From: Contact Centre (CRM) <contact@ribblevalley.gov.uk>
Sent: 16 April 2026 20:26
To: Planning
Subject: Planning Application Comments - 3/2026/0247 FS-Case-828431040

Planning Application Reference No.: 3/2026/0247

Address of Development: Spout Farm

Spout Farm

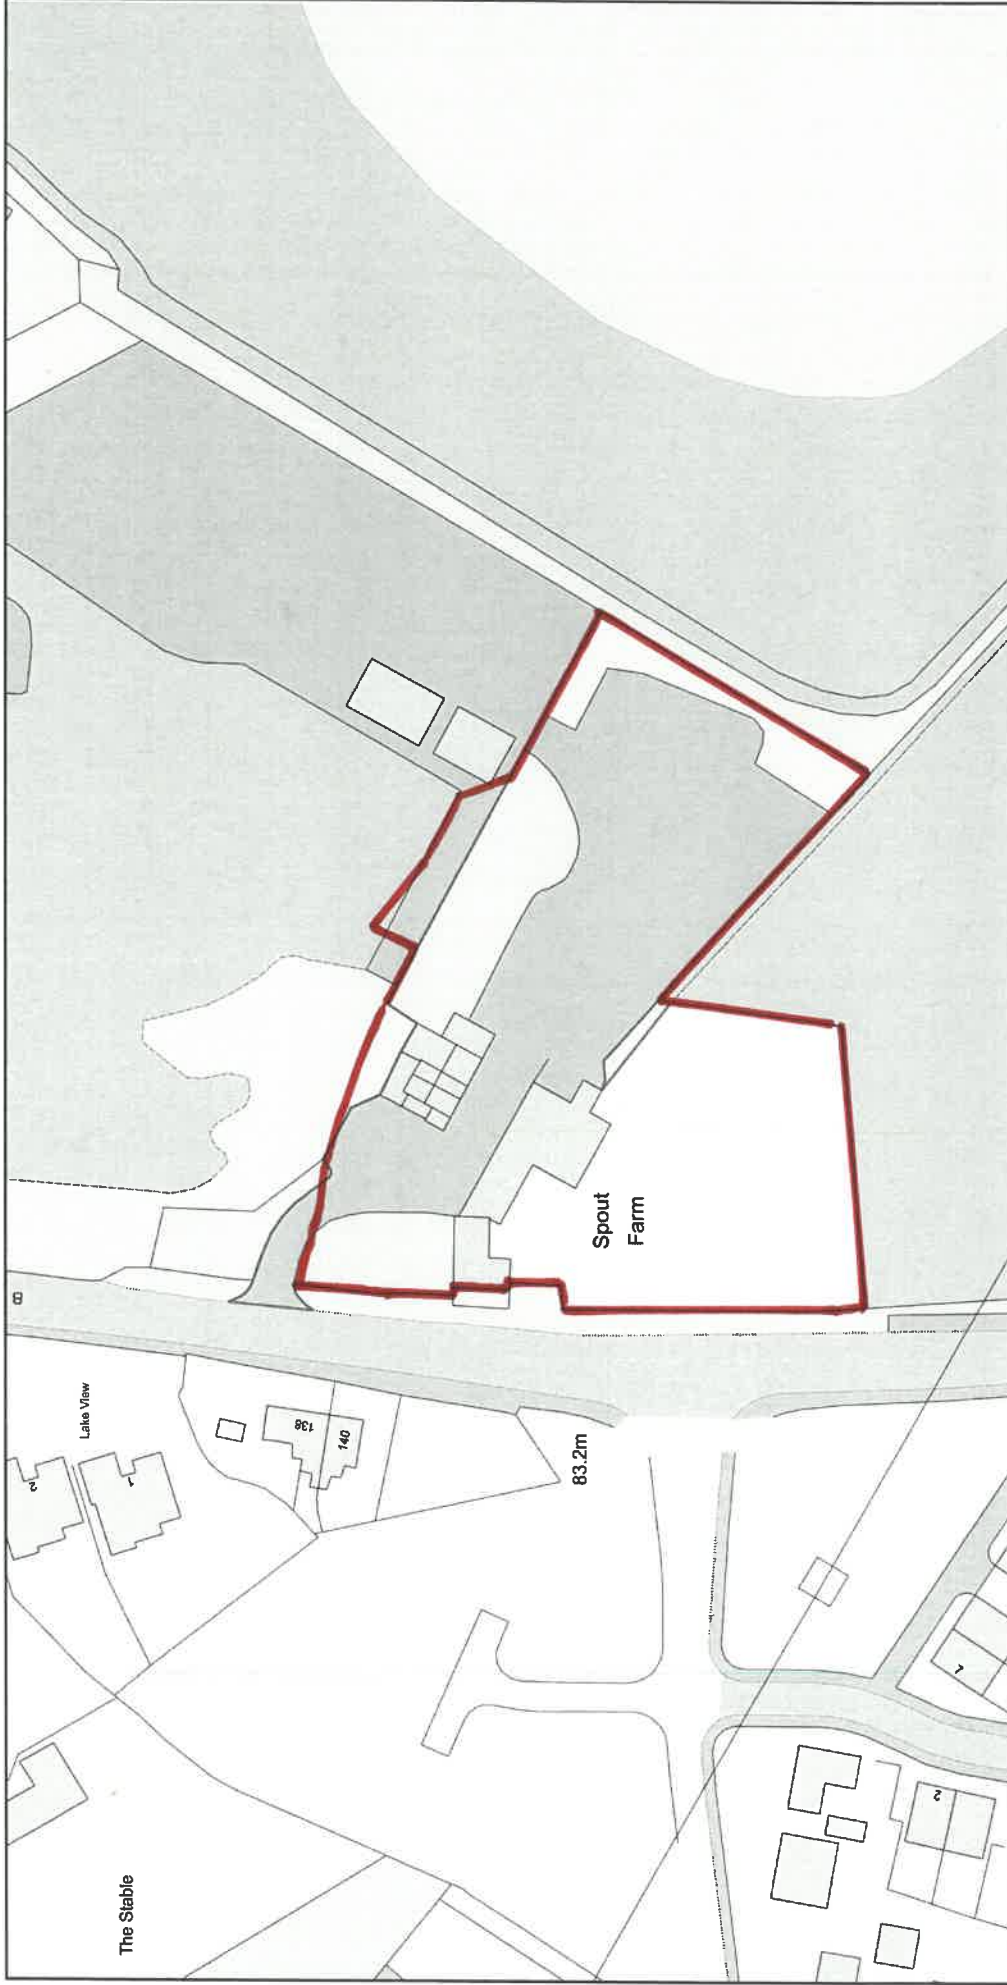
The application references our planning approval (03/2020/0309), yet the location plan submitted contradicts the approved layout. This inconsistency undermines the accuracy and reliability of the supporting documentation.

3.3.1 Reference to our own site planning and approval 03/2020/0309 which contradicts the location plan submitted on this new application. The boundary lines encroach onto the Sandpipers development Land Registry Title number LAN 242913

One of the main objections I have relates to the site location as shown in figure 1 of the planning statement. The drawn outline does not correspond to the boundary as lodged with HM land Registry shown on map LAN143371. Whilst I appreciate this is 'planning in principle', I think attention to detail should be paramount even at this early stage. Perhaps this is the reason there is also a difference in the site size - what is it? 0.74 hectare or 0.69 hectare?
